**DISCOVERY POINT STAGE 1
BUILDINGS 1B & 1 C**

ACCESS REVIEW

Morris-Goding Accessibility Consulting

3rd February 2011

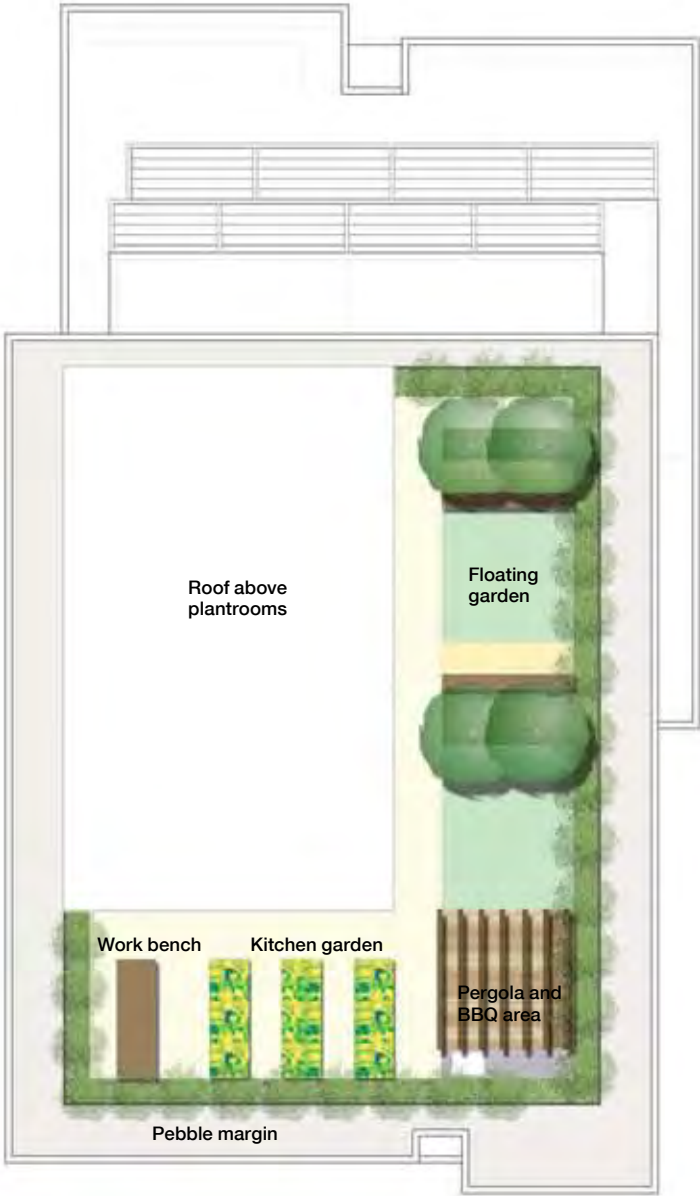
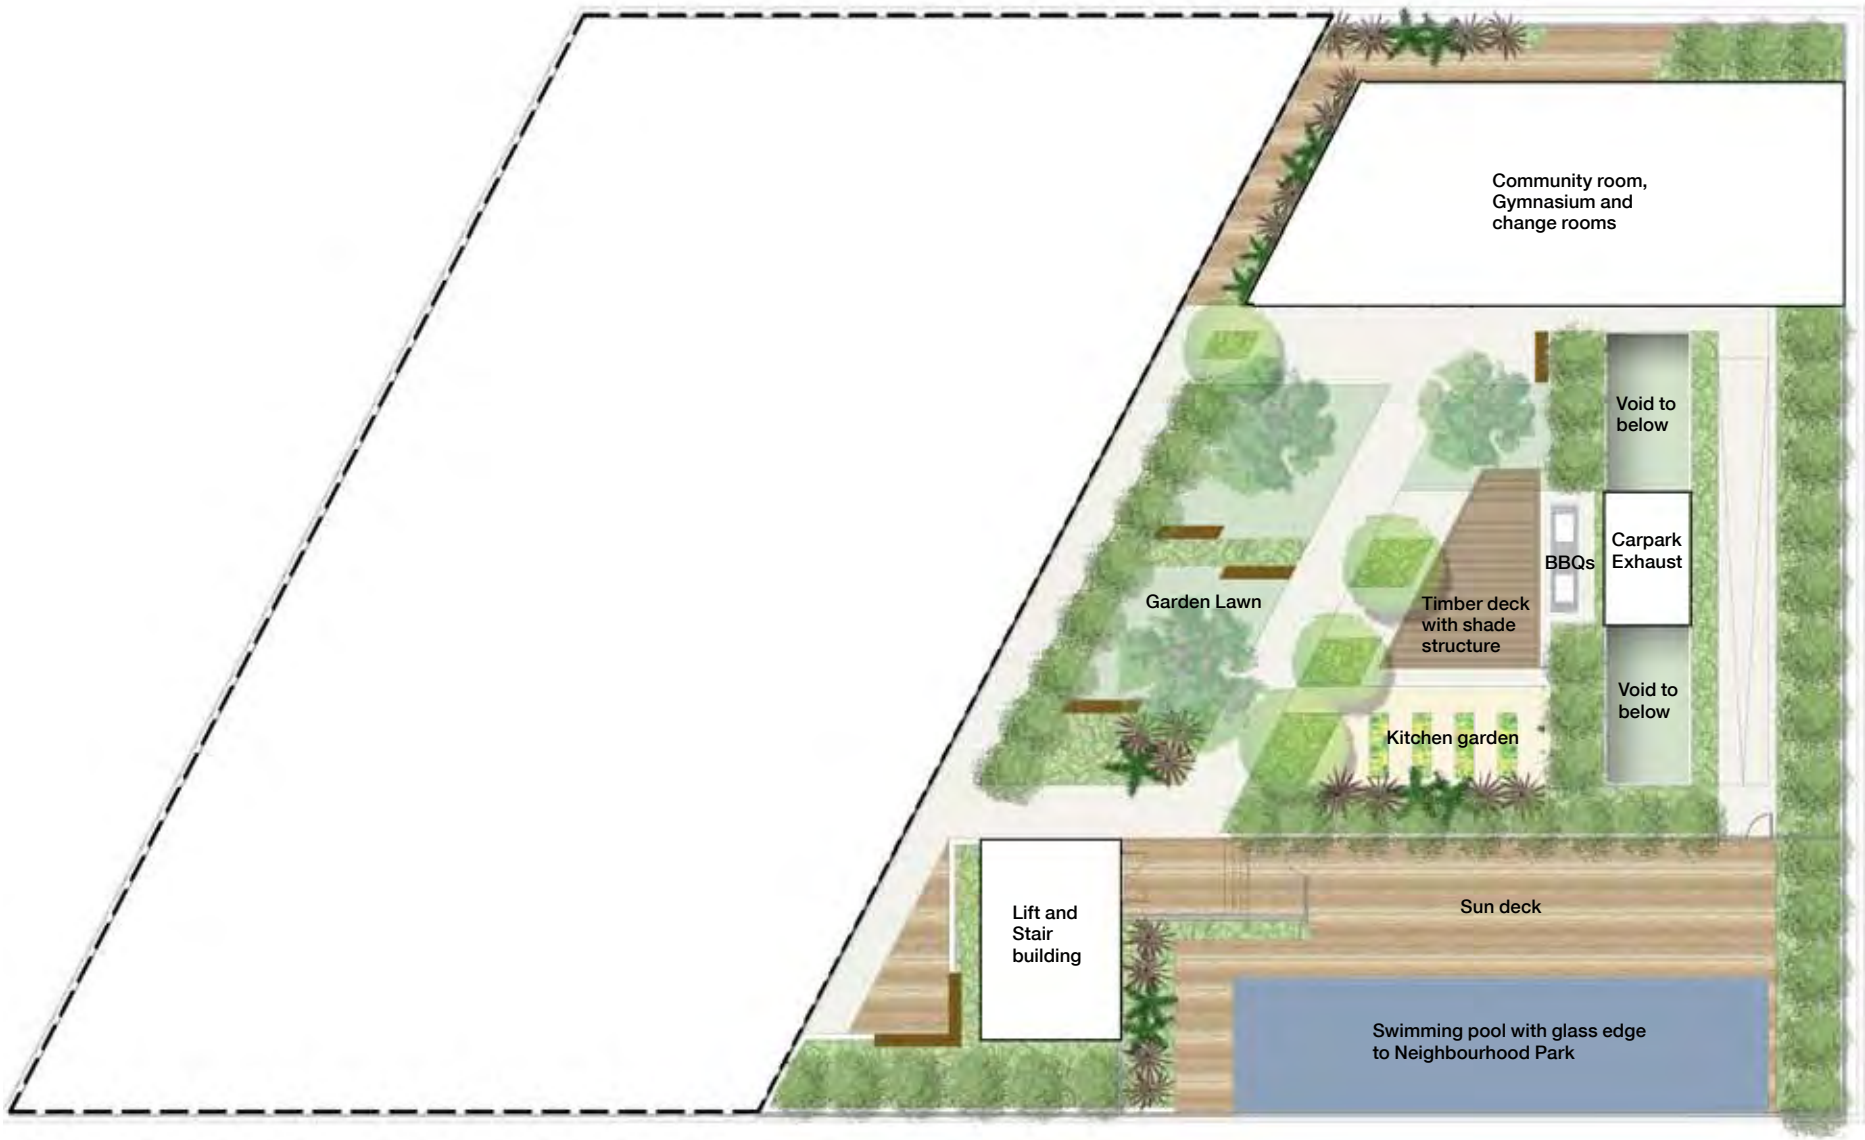
The paths of travel throughout the rooftop terrace have appropriate clear widths compliant with AS1428.1:2009. There is a stairway and an alternate 1:30 ramp access up to the pool deck at RL16.25, which will ensure access to this area for people using wheelchairs in line with the DDA Access to Premises Standard. The 'ramp' has a

suitable width and gradient however does not indicate a level landing at the doorway to pool which requires review for compliance with AS1428.1:2009.

- (i) Ensure access to and within the community room and to and within required common use areas for people with disabilities, compliant with DDA Premises Standard and AS1428.1:2009.
- (ii) Ensure 1:30 ramp has appropriate level landings, compliant with AS1428.1:2009.
- (iii) Ensure stairway has handrails on both sides and is compliant with AS1428.1:2009.
- (iv) Where common-use male and female change facilities are provided, ensure an equivalent unisex accessible change facility, compliant with AS1428.1:2009 is provided in line with DDA Premises Standard.
